Application No: AB/44/21/HH
Site Address: Fern Cottage 5A Surrey Street Arundel BN18 9DT
Description of works: Proposed loft conversion (This application may affect the setting of the Arundel Conservation Area).

Thank you for your internet representation made on 16th May 2021 which has been recorded as an objection with the comments as follows:

The Health and Safety Executive is to be notified as soon as possible before construction work starts if the works:

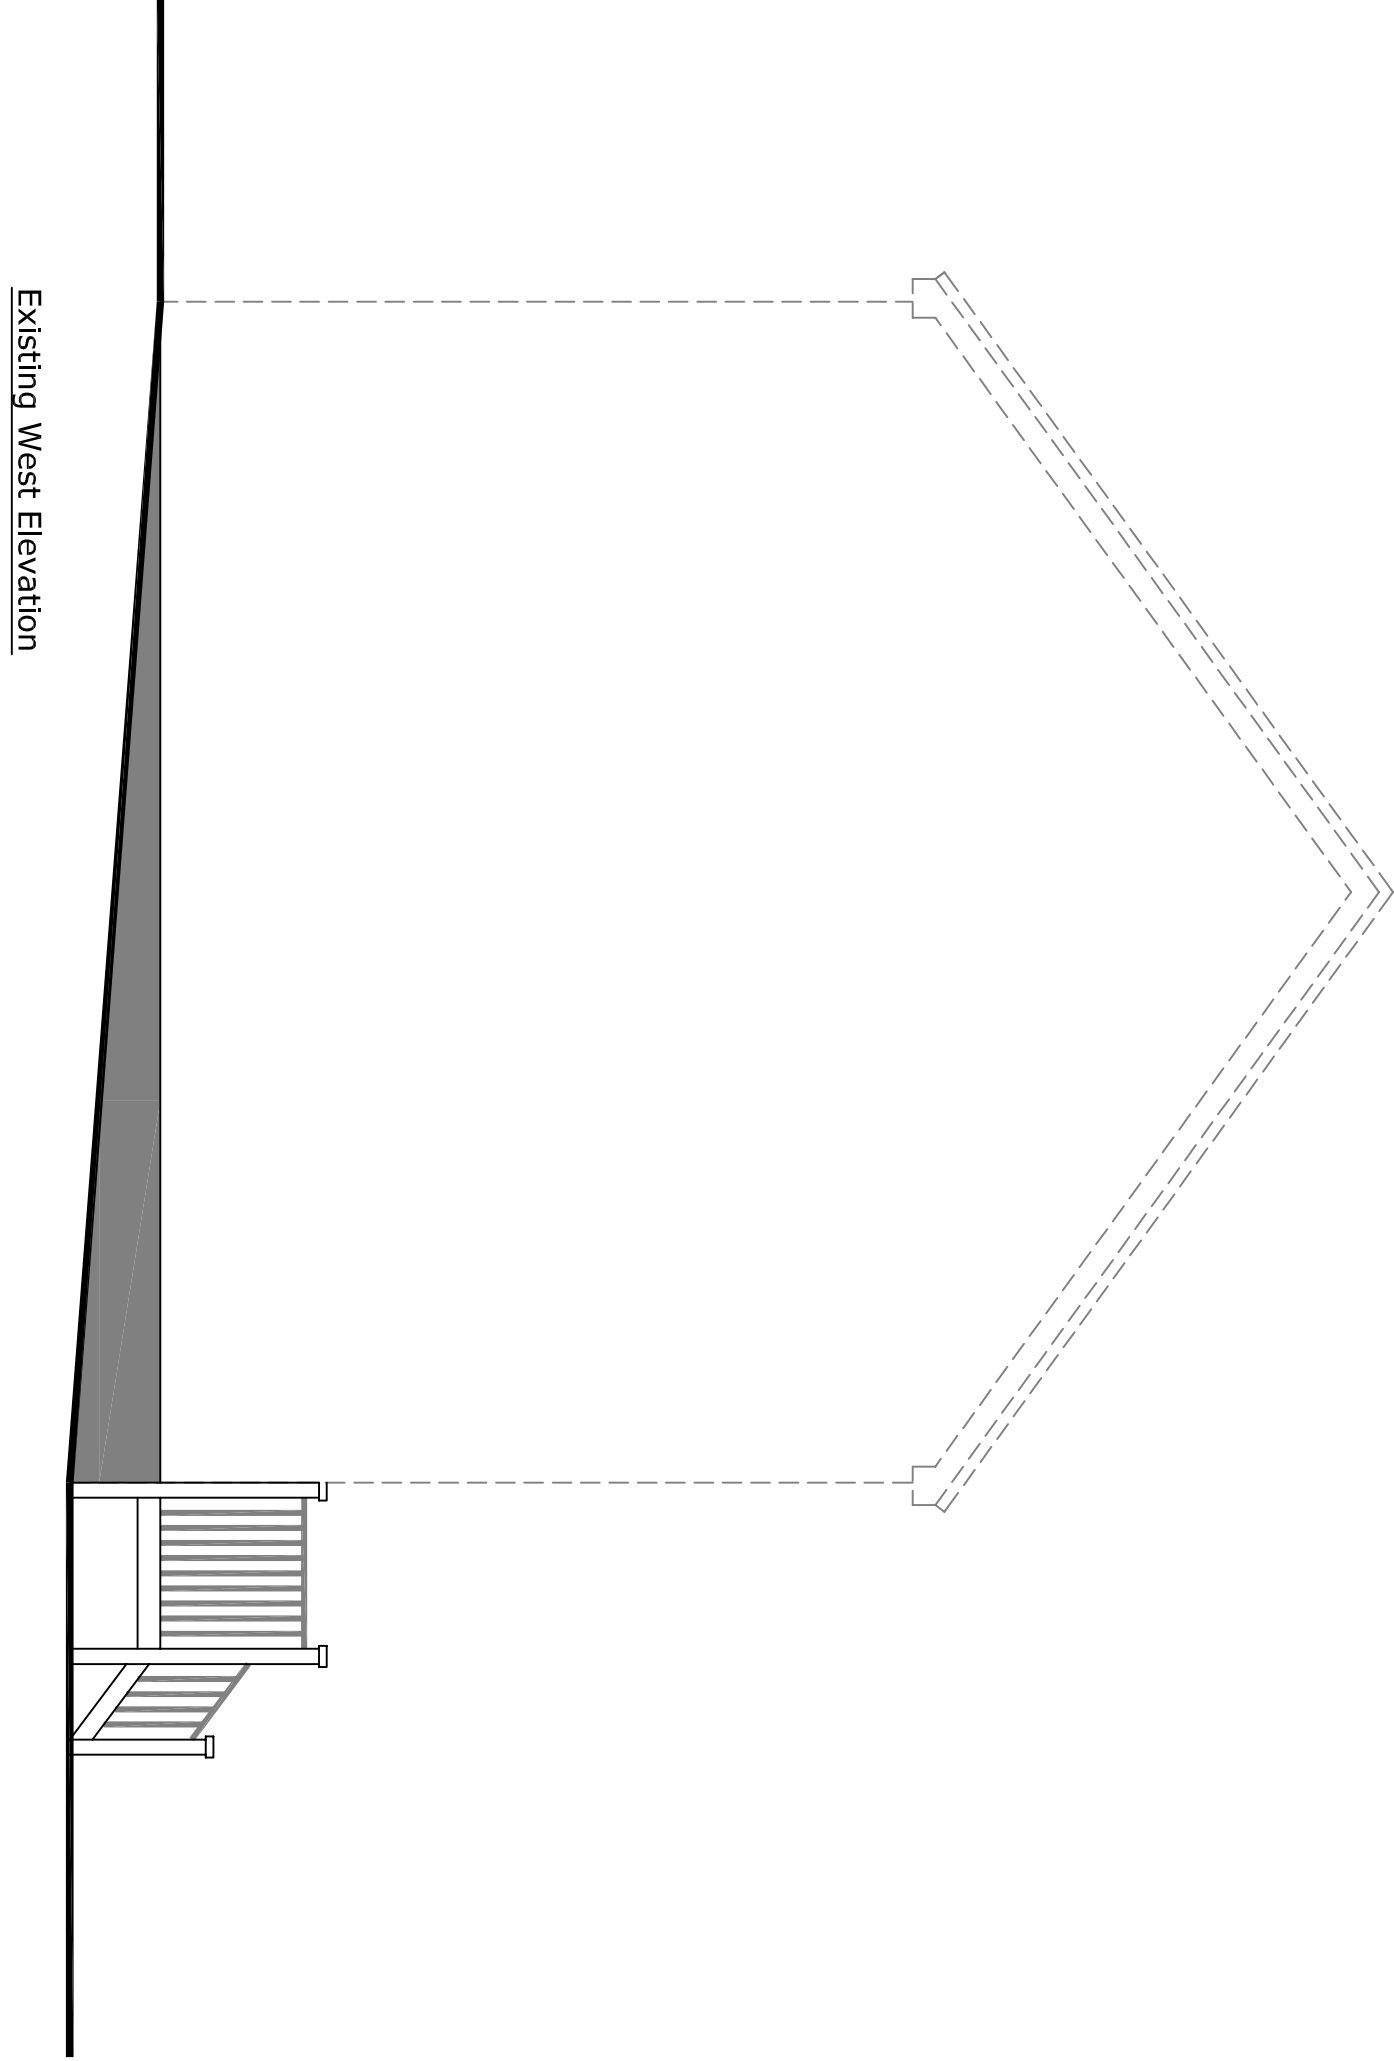
On the rear elevation a very large dormer extension is proposed which will largely not be seen from Surrey Street or The Slupe. It does, however, necessitate a change in the shape of the main roof at its eastern end which will appear incongruous when viewed from Surrey Street and School Lane.

Very large rooflights are proposed for the front elevation which will detract from the appearance of the building, the street scene, and the setting of the listed group mentioned above and other and nearby listed buildings.

The plain, unaltered, continuous, front roof slopes of 5a -25 Surrey Street are attractive features in the Surrey Street townscape but if the Council considers that it could not refuse the principle of rooflights on the street elevation of the building then they need to be smaller and of conservation style and incorporating central vertical glazing bars.
